From: Nick Howard
Sent: 30 July 2019 11:58
To: Planning.Responses <Planning.Responses@arun.gov.uk>
Subject: FW: Planning Consultation on: FP/132/19/PL

APPLICATION NO: FP/132/19/PL

Site Address: Grassmere Parade, Shop 3 Felpham Road Felpham PO22 7NT

Description of Works: Change of use from a Launderette (Sui Generis) to use as cafe (A3 Restaurants & Cafes). Installation of fully functional commercial kitchen & extraction system at the rear of the premises using the existing space.

Proposed kitchen layout

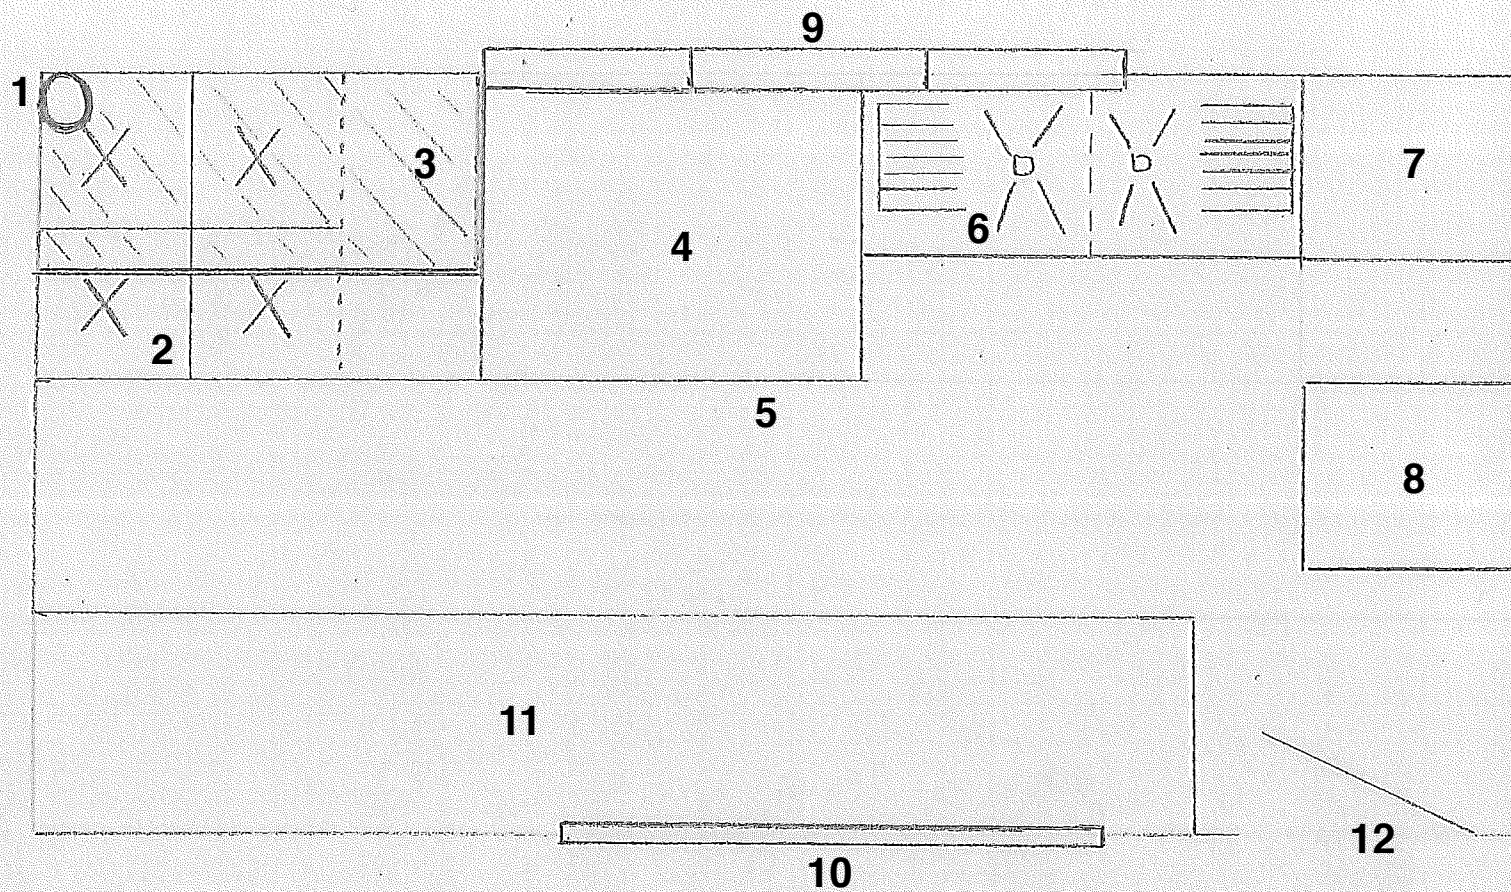
I have viewed the proposed kitchen ventilation system but I am unable to make a full assessment as I have little detail on the type of ventilation filters proposed to be used to mitigate odour nuisance and the type of noise mitigation methods for the kitchen ventilation system e.g. fan/s and canopy ductwork as there are close receptors living near the shop.

I would advise e.g. anti-vibration mounts are always used for the ventilation duct work and additional sound insulation provided between the ground and first floor.

The use hereby permitted shall not be carried on unless and until details of a suitable system for the extraction of cooking odours (including details of the extract fan units, filters, extraction hoods and ducting together with method of noise abatement) has been submitted to and approved in writing by the Local Planning Authority.

The equipment approved under this condition shall be installed by a competent engineer before the use hereby permitted commences and thereafter shall be maintained in accordance with the manufacturer's instructions.

PROPOSED
FLOOR PLAN

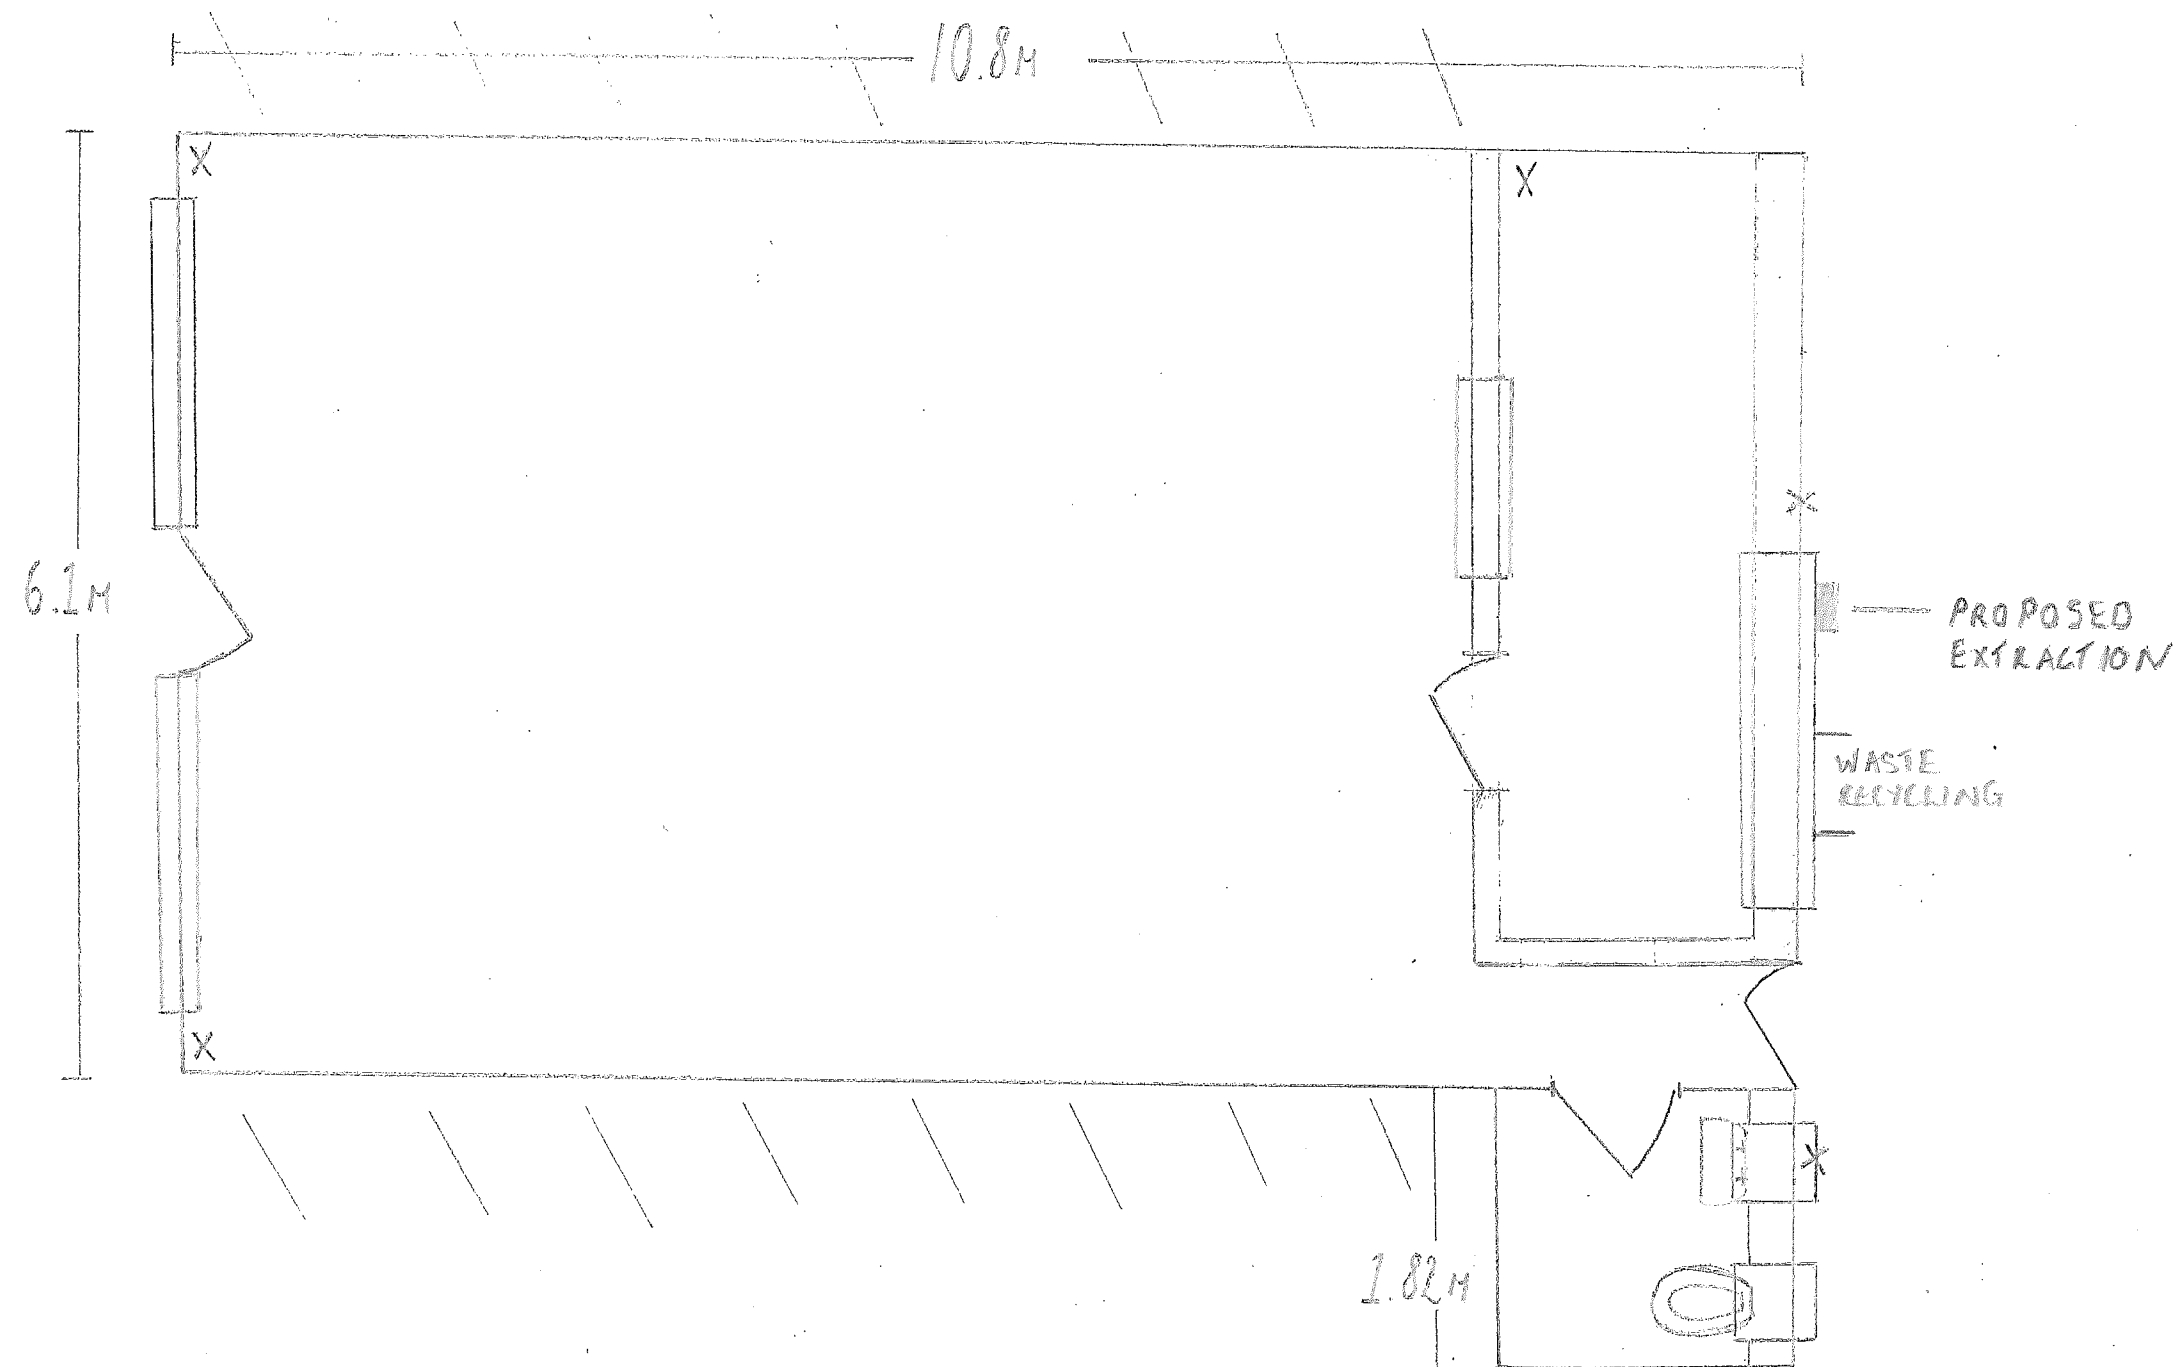
I noted on the plans that you propose seating in the café/restaurant for >30 people. For this amount of people eating in the shop you would need to install another toilet. Please refer to attached Arun DC toilet provision document for guidance.

The use hereby permitted shall not be carried on unless and until details of a suitable provision of sanitary accommodation (in line with the guidelines set out within the Arun District Council document entitled: 'Provision of sanitary accommodation in food businesses') has been submitted to and approved in writing by the Local Planning Authority.
